**KIRKLEES METROPOLITAN COUNCIL
INVESTMENT & REGENERATION SERVICE**

Reference No: 2019/62/90211/W

Site Address: 2, Drake Hill Cottages, Hey Slack Lane, Whitley
Common, Huddersfield, HD8 8YD

Description: Erection of first floor extension over detached garage

DRG No:19_100.2A

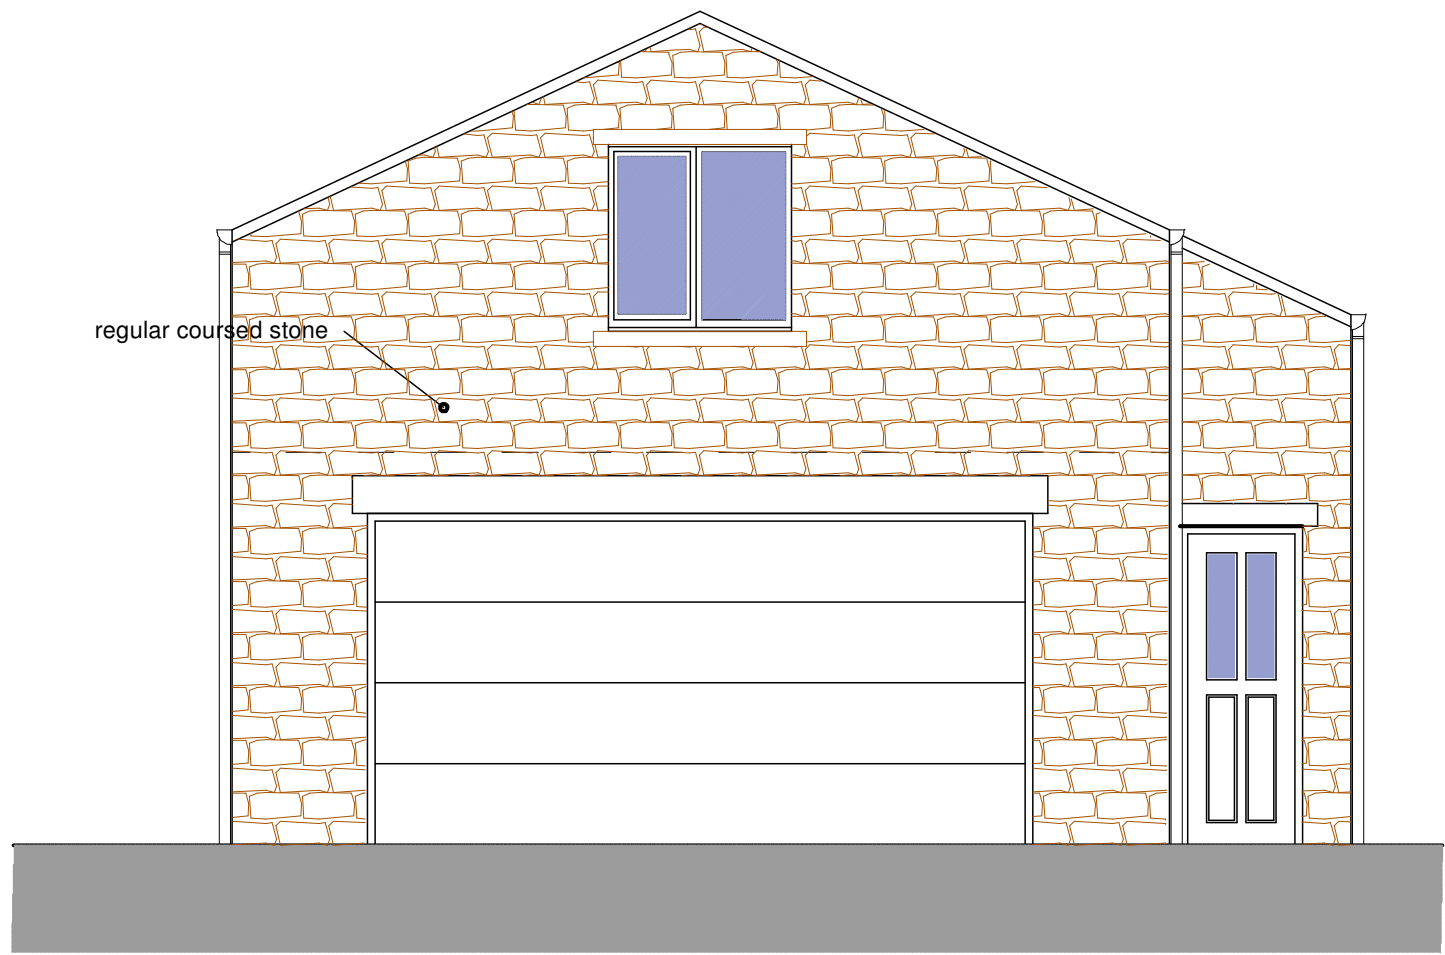
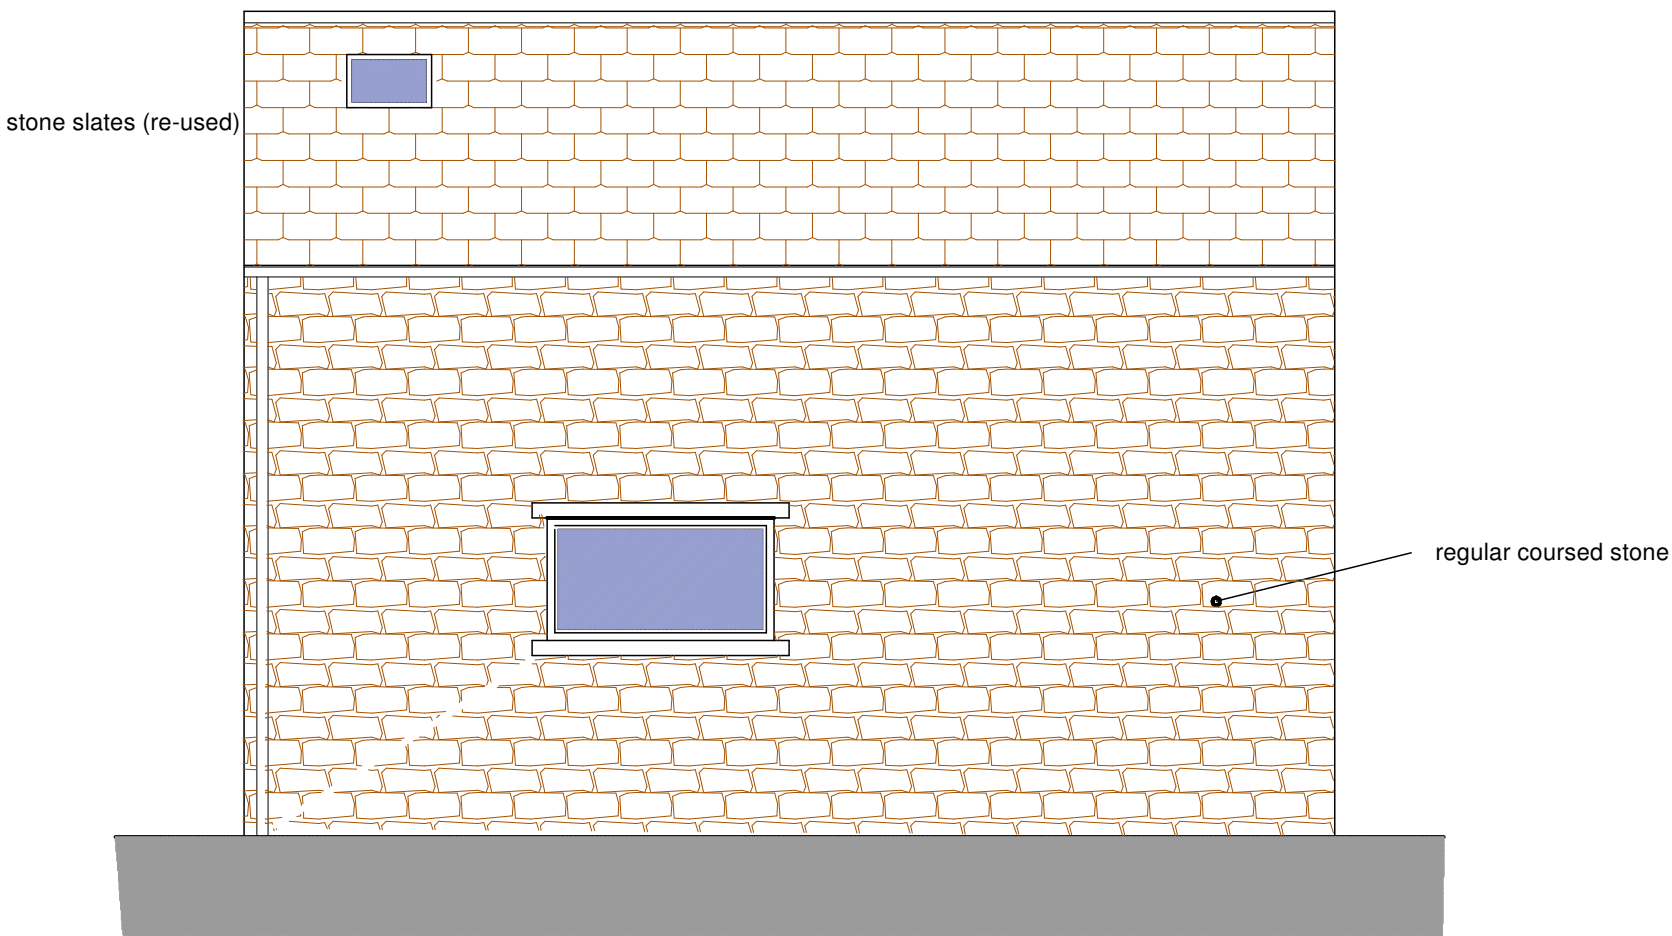
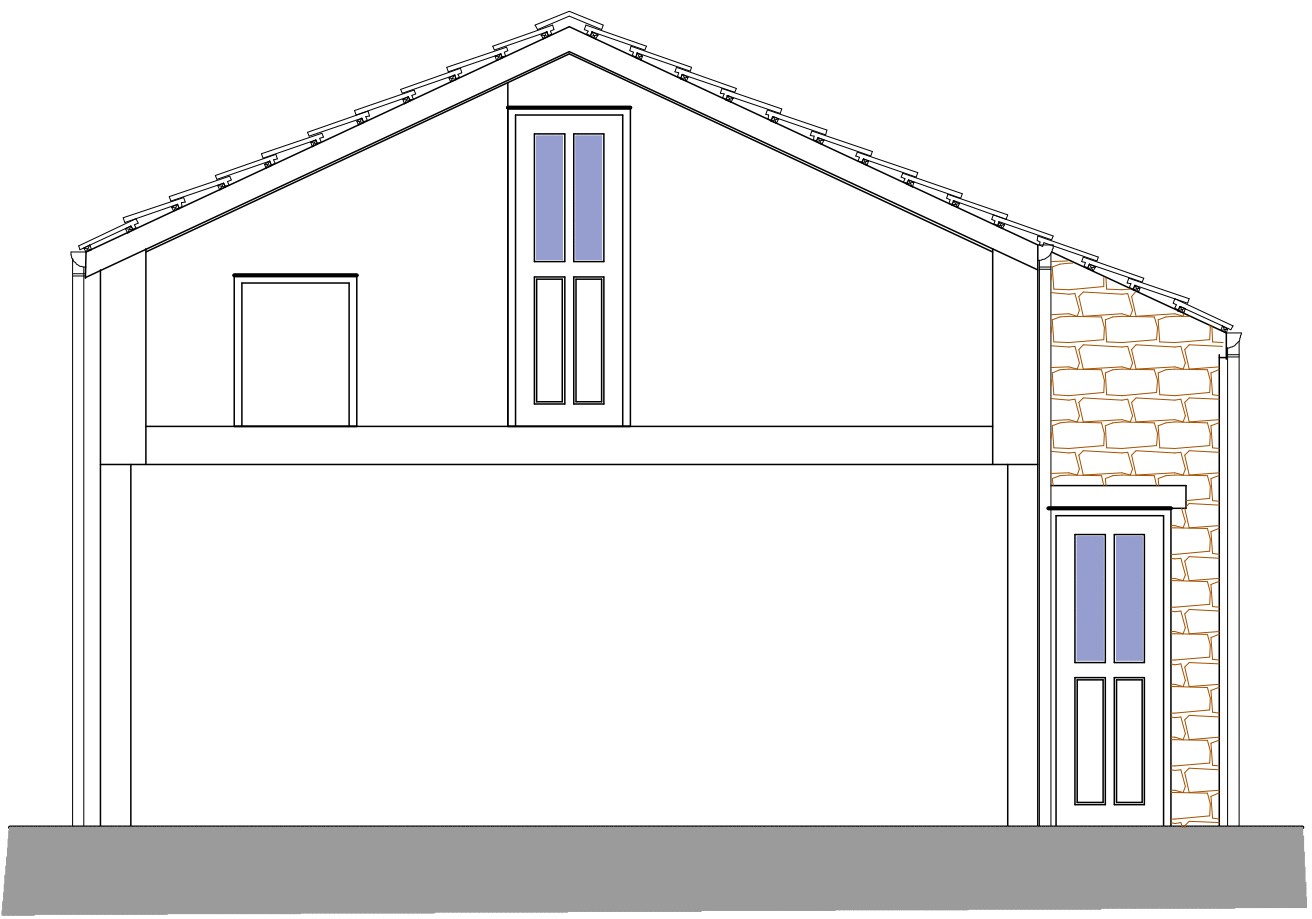
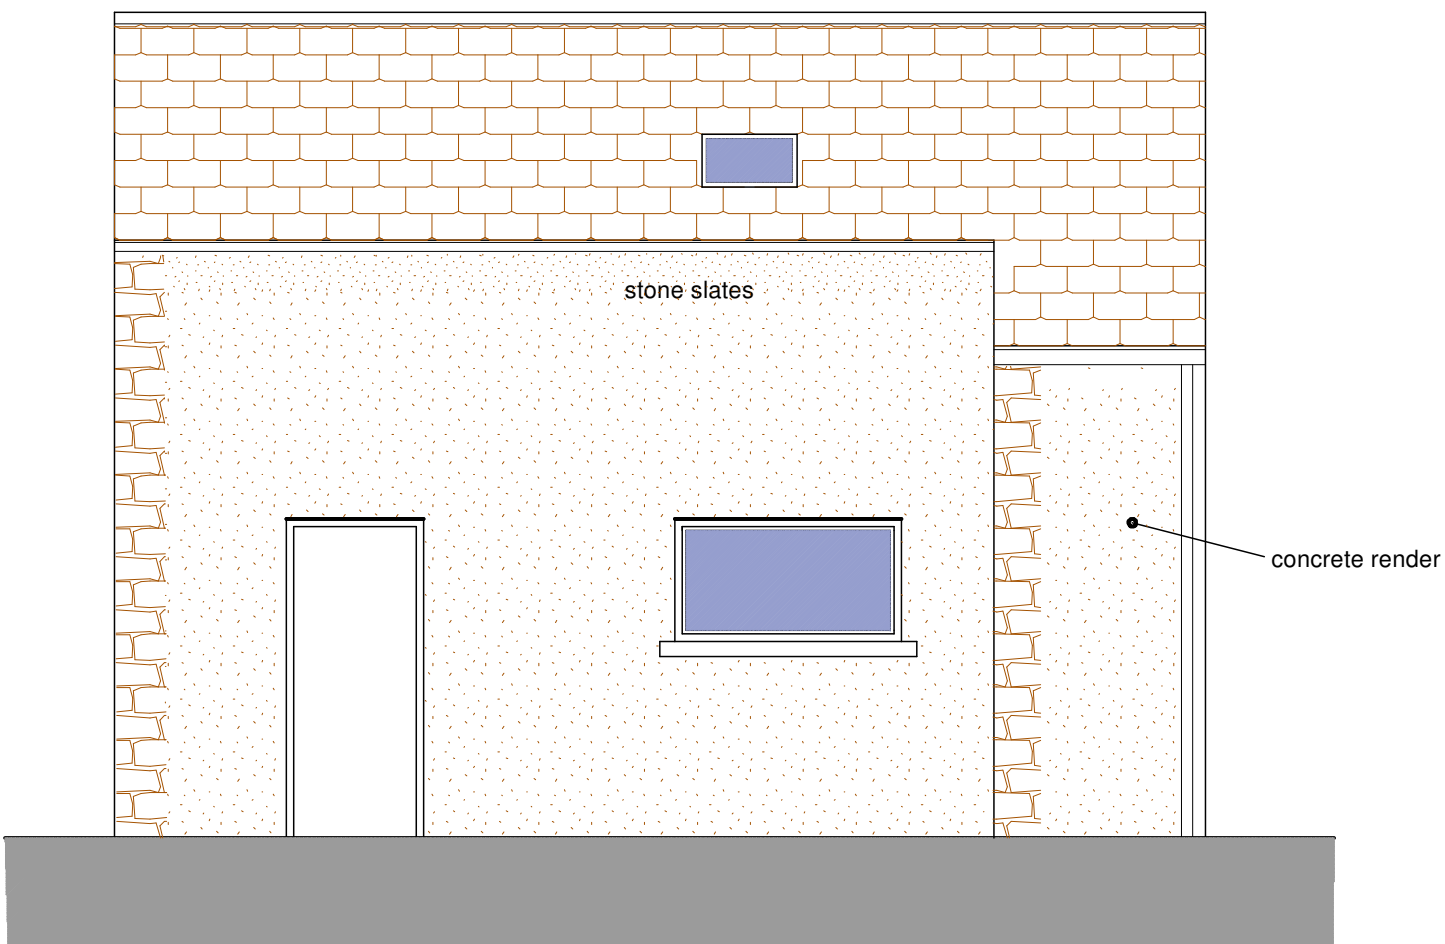
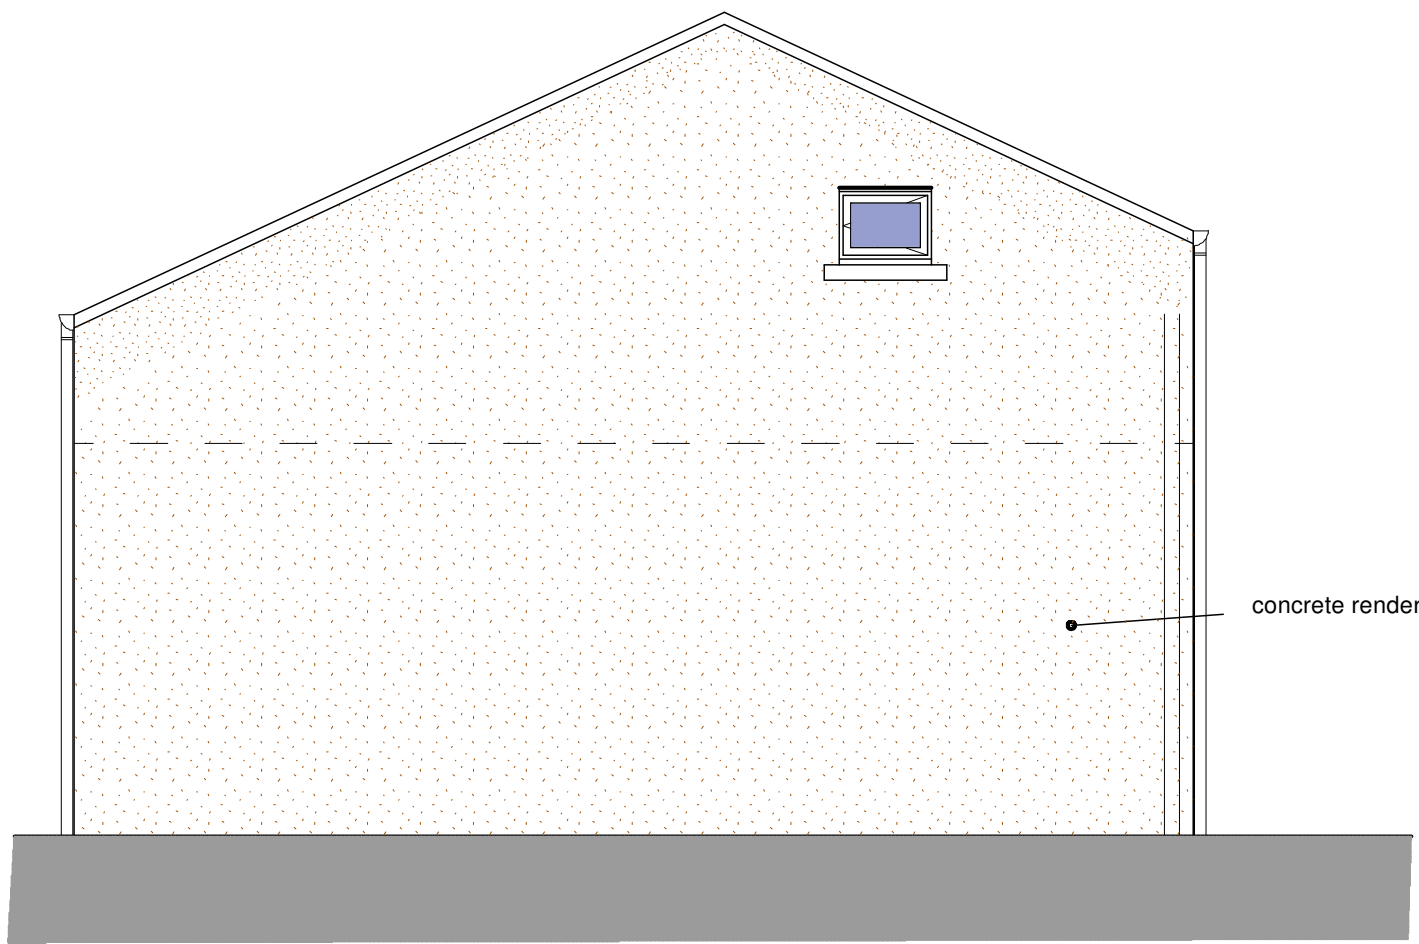
In this case the proposed extension to the garage, by virtue of its two storey scale and prominent position is not considered to respect the size and overall appearance of the dwellinghouse. The garage is positioned to the side of the host dwelling as you travel north up Hey Slack Lane and the garage would appear as being two storeys in height and would be 0.3 metres higher than the eaves of the adjacent dwellinghouse. Given this scale it is not considered that the extension would be a subservient addition. Furthermore it is considered that the garage would detract away from the host property and the scale would emphasises the incongruous size and nature of the proposed garage. It is therefore considered that the extension would appear out of character to the host property with regards to scale and character and be directly contrary to PLP57 a and PLP24.

Turning to the scale of extensions at the host property and cumulative impact of extensions to the original building. The original property within the site of no.2 Drake Hill was approx. 570m³, with the existing first floor rear extension combined with the existing garage and garage extension as proposed would in total add 225.7m³ of building form, or an addition of 39% to the original property. These figures were calculated from the approved plans for the 91/02688 application and the plans submitted for this application. An increase of 40% would represent a significant addition to the original building. This level of additions combined with scale and massing of the proposed garage extension particularly its two storey nature and appearance in relation to the host property, are considered to lead to the development representing a disproportionate addition to the original dwelling.

1. The proposed extension to the garage, by reason of its two storey scale and design would result in an incongruous feature in the street scene due to its prominent position and when viewed in the context of host residential property to the detriment of the character of the local area. To permit such a development would be contrary to Policy PLP24 (a) and (c) (as modified) of the Kirklees Local Plan, and Chapter 12 of the National Planning Policy Framework.

2. The proposed garage extension when considered cumulatively with the previous extensions to the host property combined with its overall two storey scale would result in the development representing a disproportionate addition, over and above the size of the original building, which would have a greater impact on the openness of the Green Belt. The proposed development would therefore represent inappropriate development within the Green Belt. No very special circumstances have been put forward to outweigh the harm to the Green Belt by reason of its inappropriateness and other harm. The proposal would therefore fail to accord with the requirements of Policy PLP57 (as modified) of the Kirklees Local Plan and Policies in Chapter 13 of the National Planning Policy Framework.
